**Consultation Response from KC,
Conservation & Design****2023/90332 Titanic Mill, Low Westwood Lane, Linthwaite, Huddersfield, HD7 5UN****Listed Building Consent for replacement of existing solar panels and erection of new solar panels (within a Conservation Area)****Date Responded: 06.06.2023****Responding Officer: Sebastian Pickles****Responding Ref:**

As Proposed - North-West Elevation  
Scale: 1:200

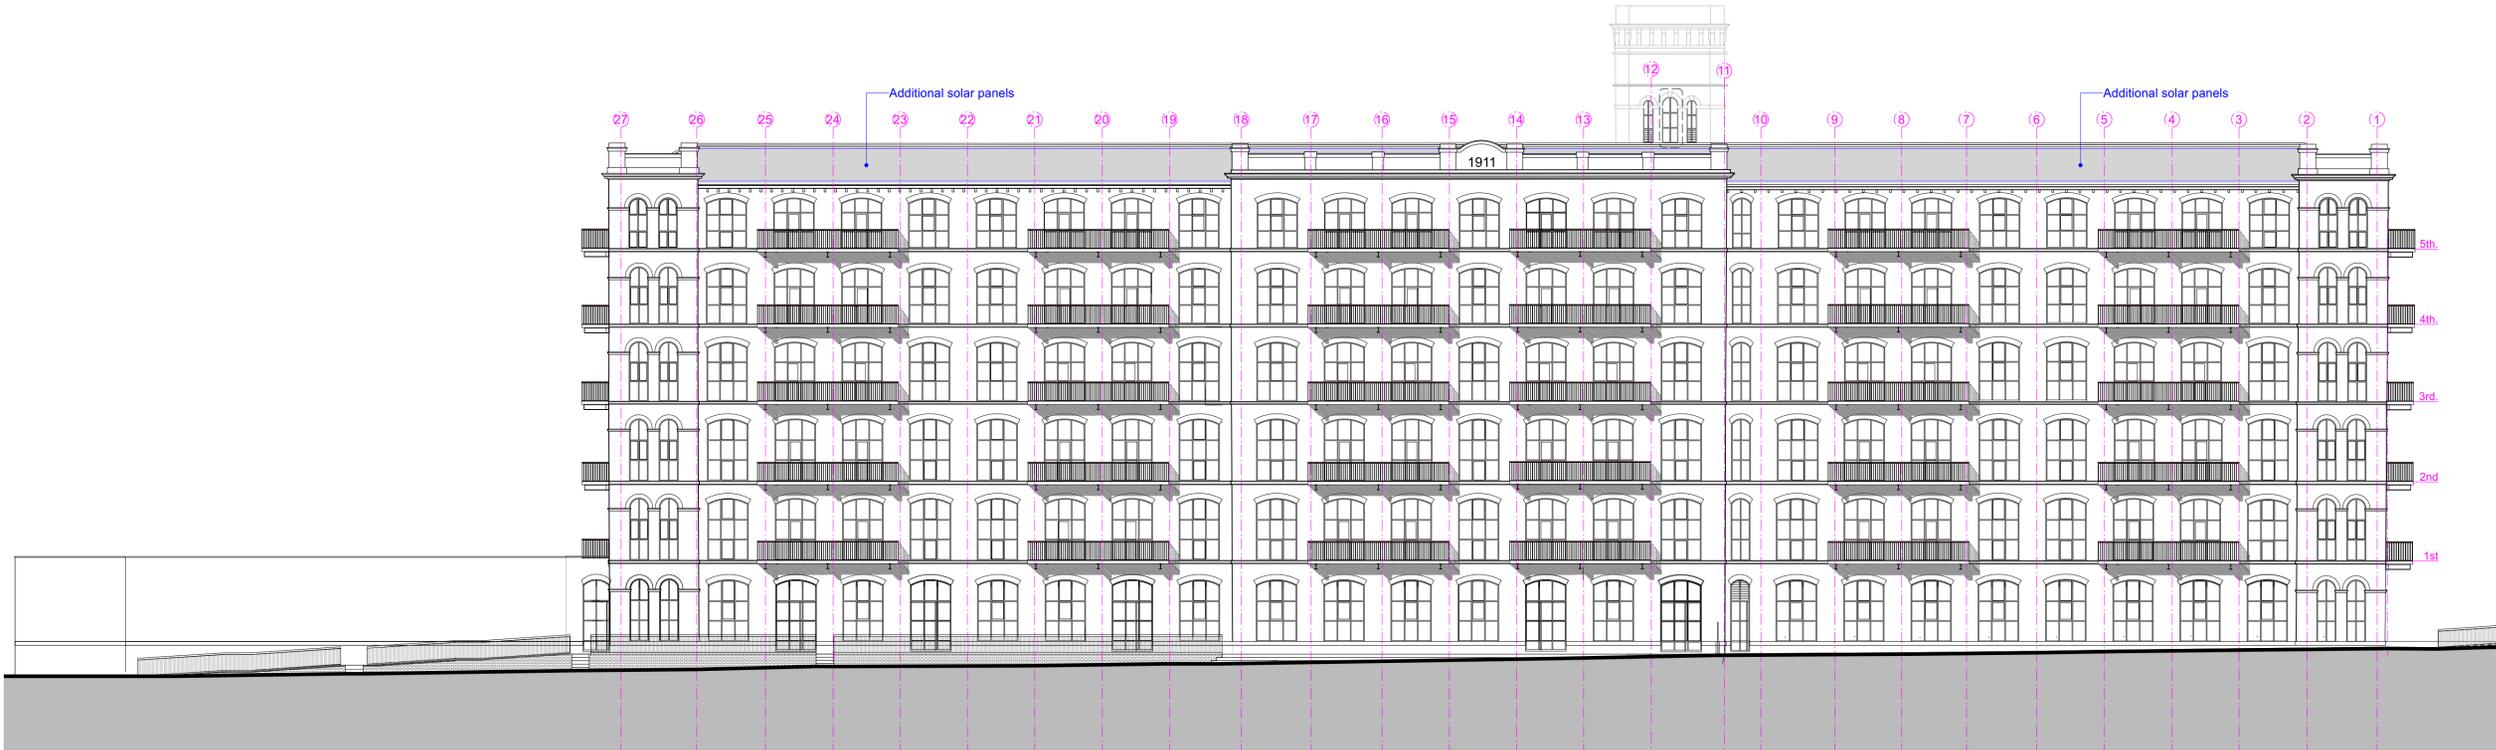
We would however raise an objection to the placement of solar panels on the north-western roof plane. Panels on this roof would be highly visible and have a harmful impact to the listed mill. While it would see the addition of some solar panels, we are not convinced that there is sufficient benefit to outweigh the harm which would be caused.

We would, however, raise an objection to the proposed placement of panels to the outer roof planes on the north west and south east, as it is considered that this would have a harmful impact on the listed building and would not accord with Policy 16(2) of the Planning (Listed Building and Conservation Areas) Act, nor Policy 202 of the NPPF.

As Proposed - South-East Elevation  
Scale: 1:200

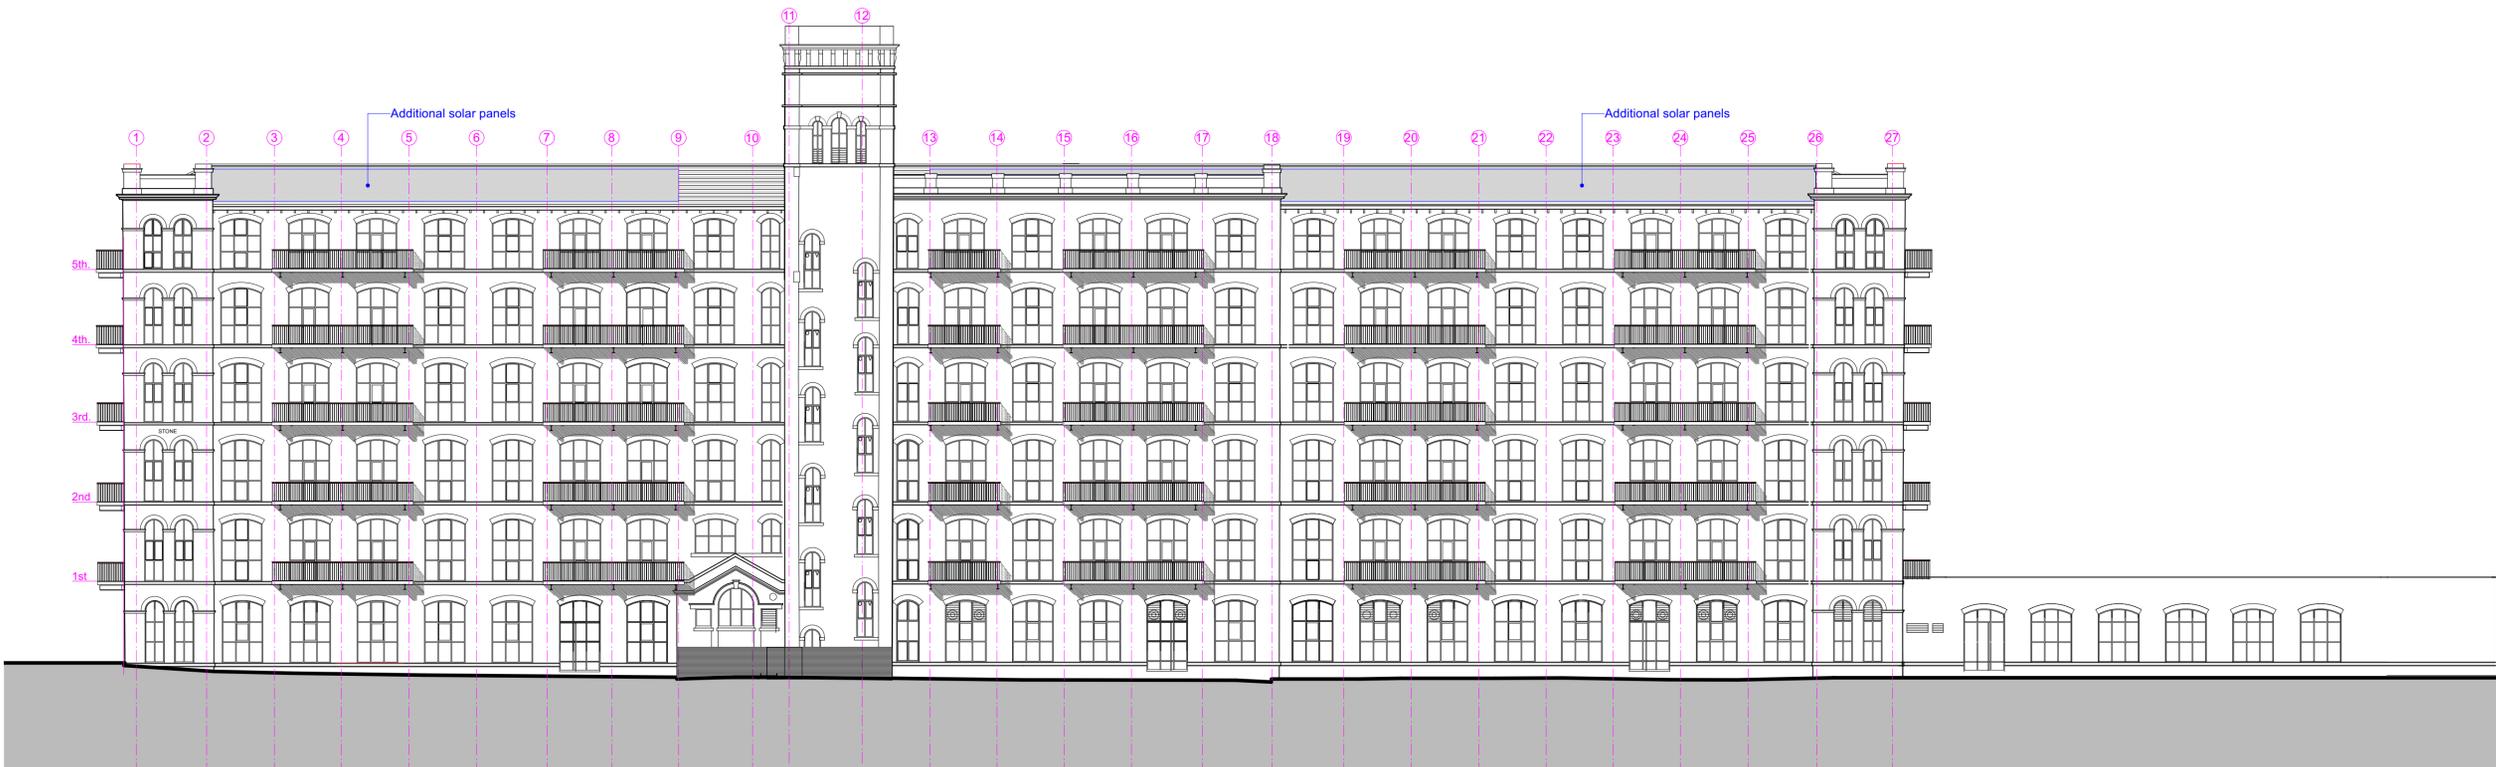
However, as set out we may be able to support a small run of panels to the south east roof plane, to be located behind the short section of the parapet. Subject to amendments as set out, we could support the proposals, however in current form, we are not able to fully support the proposals.

As Proposed - Roof Plan
Scale: 1:200

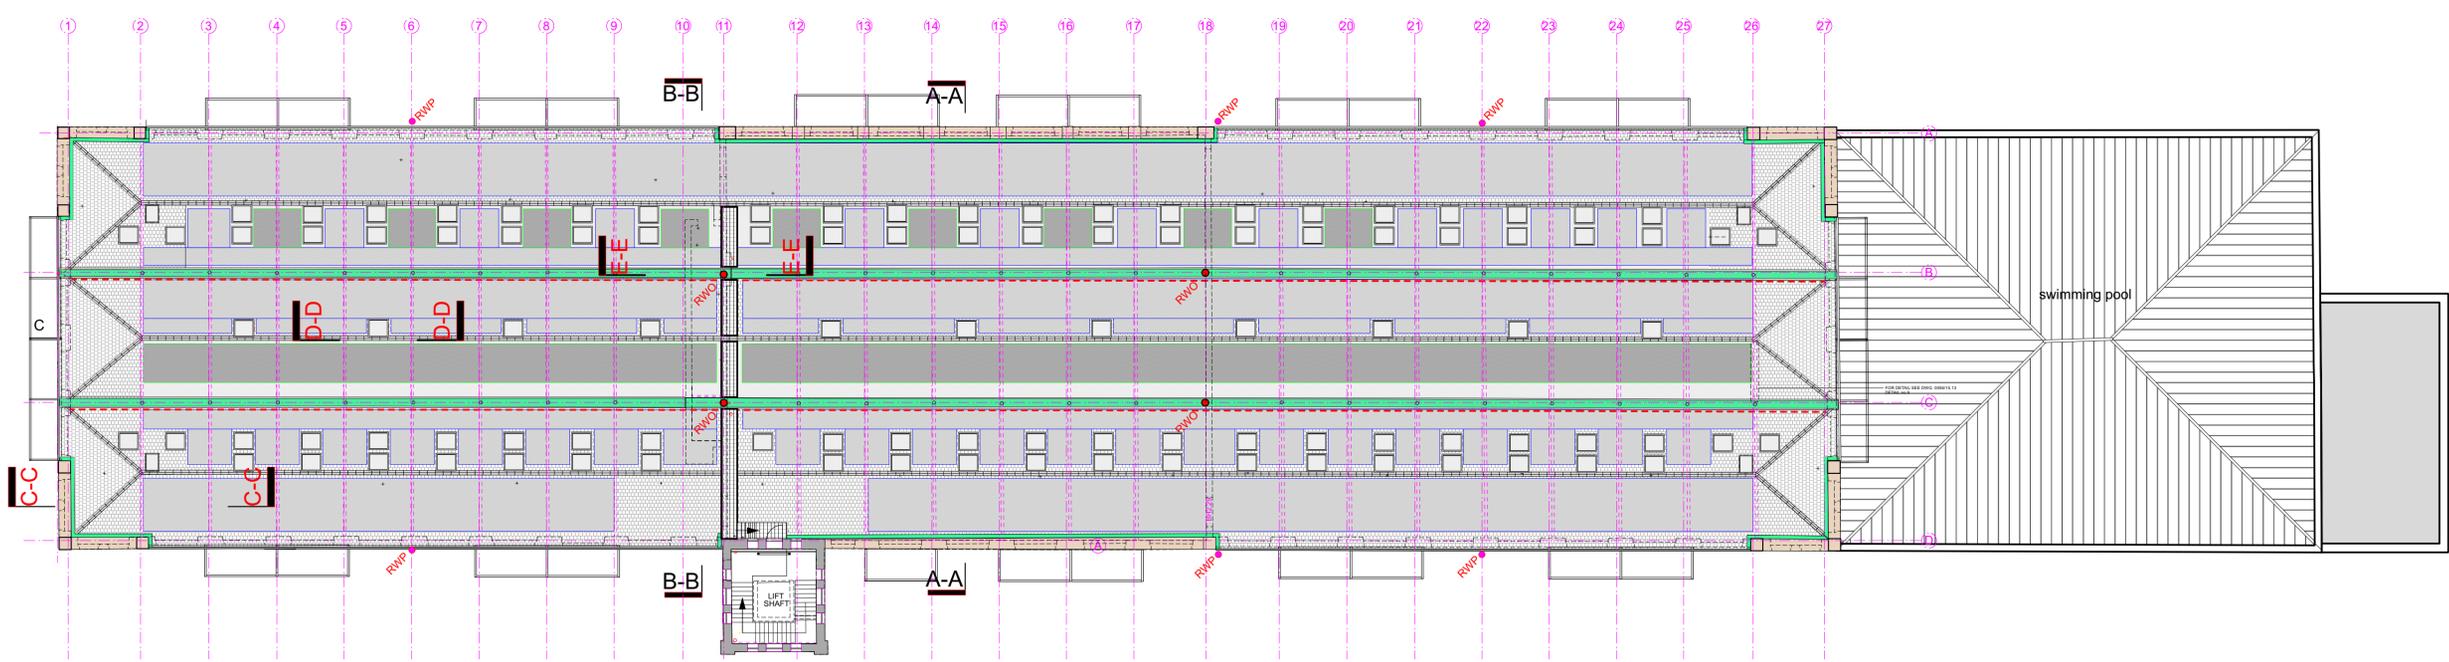
When consideration was given the placement of the existing solar panels, it was agreed that panels within the internal roof valleys were acceptable, as they were entirely concealed. We consider that the replacement of the existing panels is acceptable, as this impact has already been assessed and found to be acceptable. We would equally accept additional solar panels within the internal roof valleys, as they will not have any additional impact as they too will be concealed. We would however ask that the roof structure is capable of taking the additional load and that there will be no additional internal works required to accommodate the additional panels to the internal roof valleys.

As to the south-western roof plane. This roof plane is mostly visible off Manchester Road and on the approach to the Mill down Bargate. This being said, there is one small section of the roof which has a short section of parapet to the side of the central tower. Given the parapet provides a reasonable degree of screening we consider that it would be possible to allow for a short run of panels in this location and we have indicated this on the plan below for clarity.

As set out we are supportive of the replacement of the existing solar panels and the additional panels to the internal roof valleys, which will not have any detrimental impact on the listed mill.
